## Attachment 1 Department of Planning, Industry and Environment Comments

Figure 3.5. Location of waste storage areas during operational phase (residual waste marked by red squares).

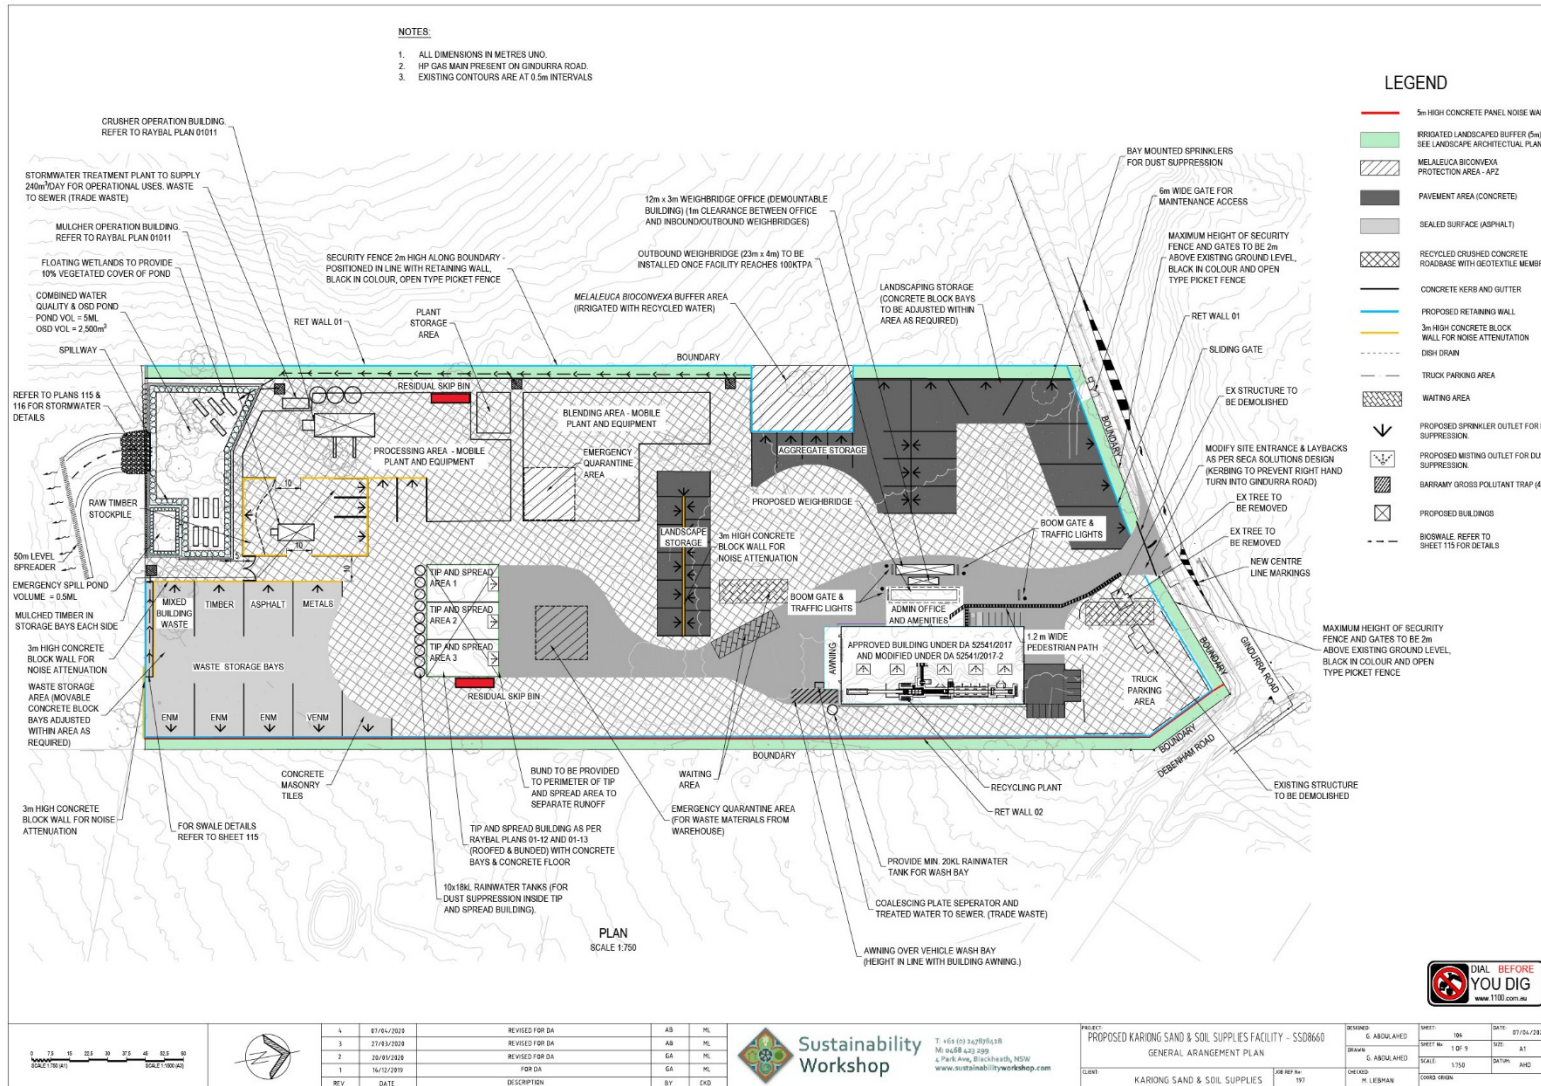
20. The Department notes Figure 3.5 of the WMP shows skip bin locations, but these locations are not shown on the civil plan. Please update the civil plan to ensure its consistency with the WMP.
